**WEST SUSSEX COUNTY COUNCIL
INFRASTRUCTURE CONSULTATION**

SUBJECT: CM/14/10/DOC- Application for approval of details reserved by condition 4, 5 and 7 following the granting planning permission CM/13/07.

Field Place, Church Lane, Climping, West Sussex, BN17 5RR

Scale 1:200

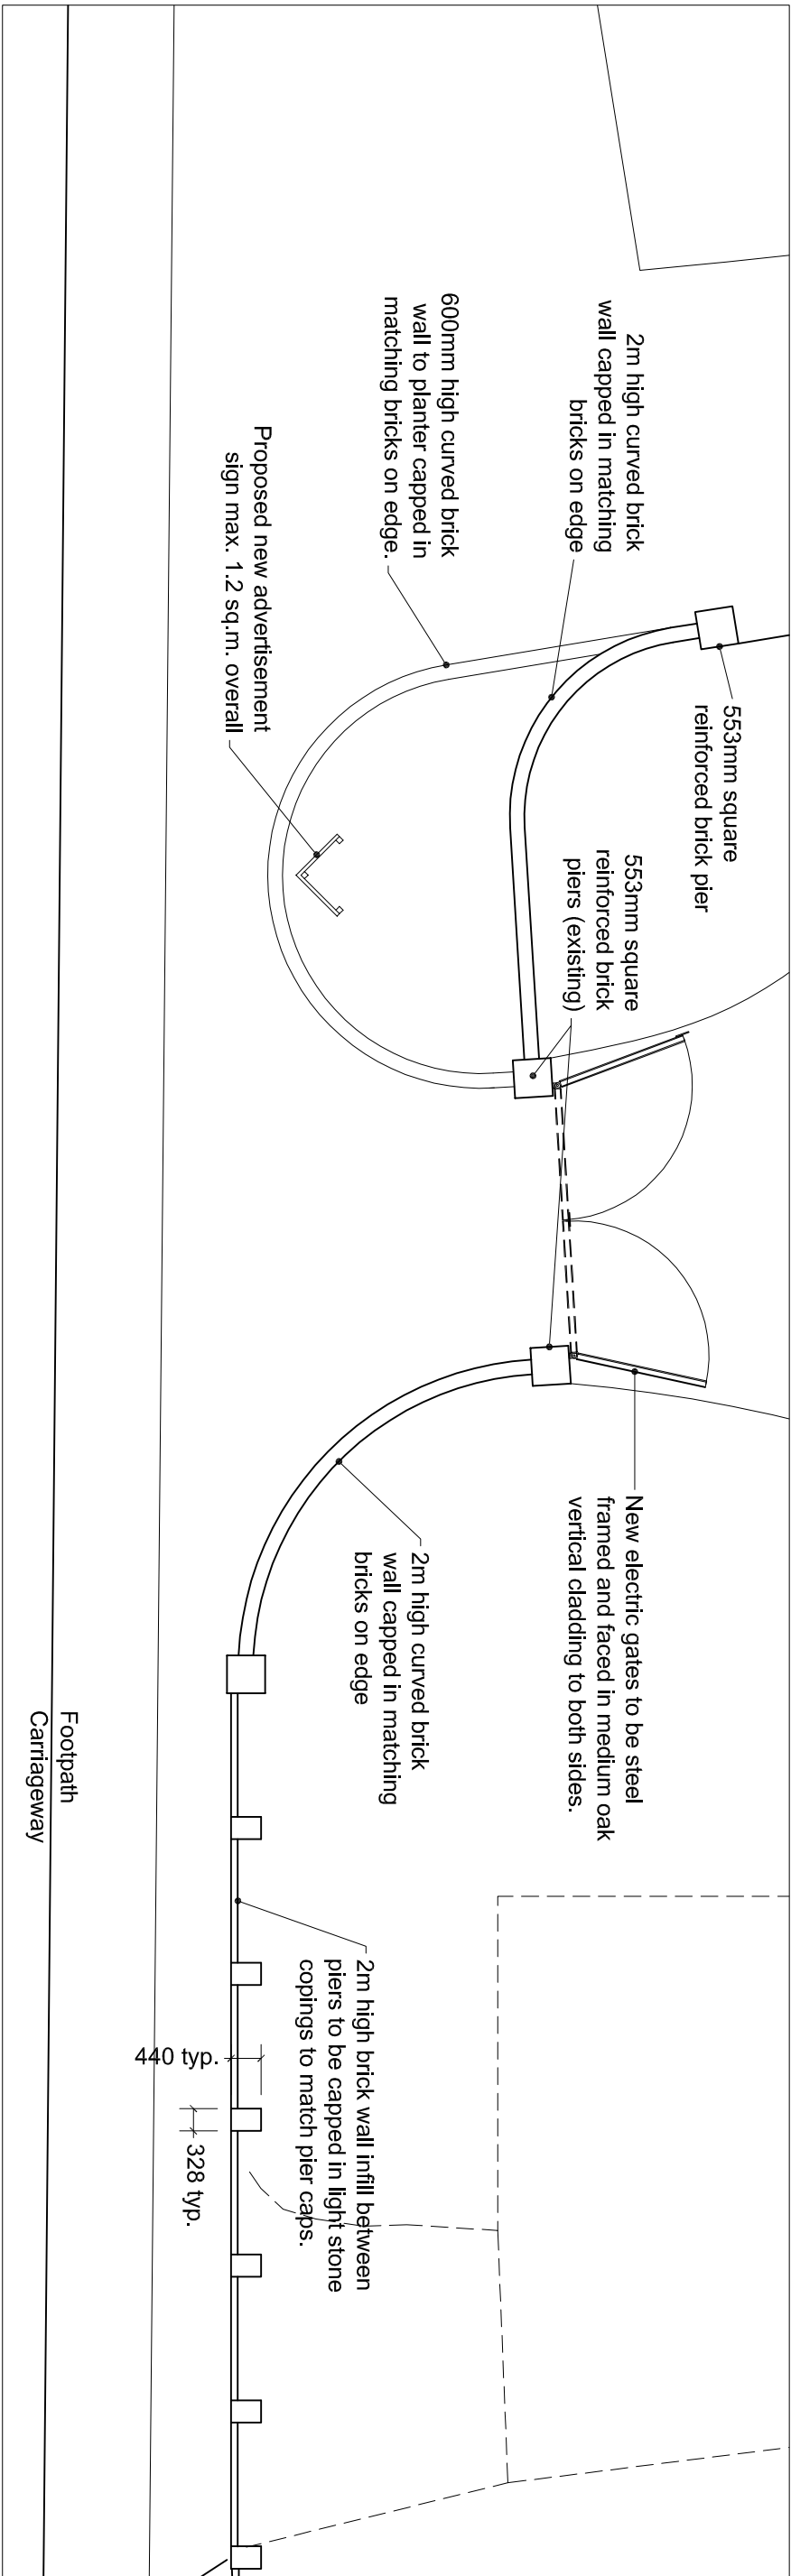
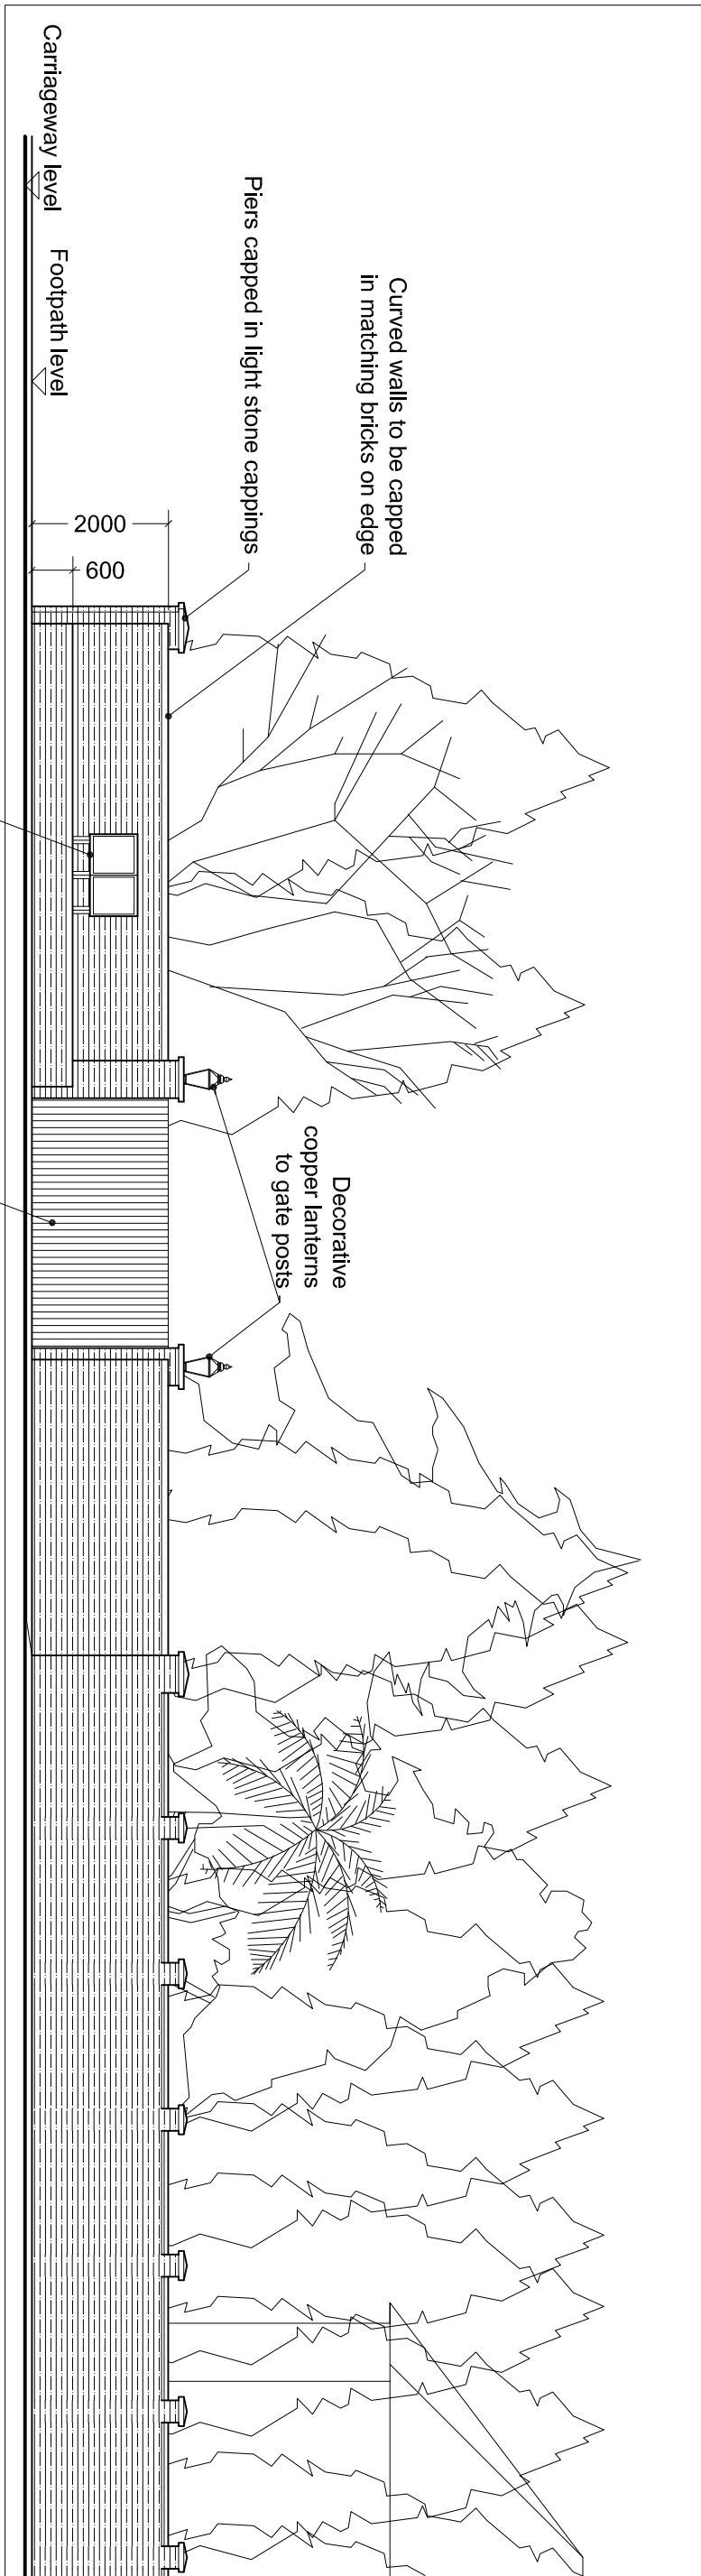
The proposal and its particular are described above. Looking at ADC's website there do not appear to be any plans that show the requested visibility splays (of 2.4 by 120 metres), new access and gates and pillars shown at the point of access. I would appreciate if these details were shown on a scale 1:500 plan.
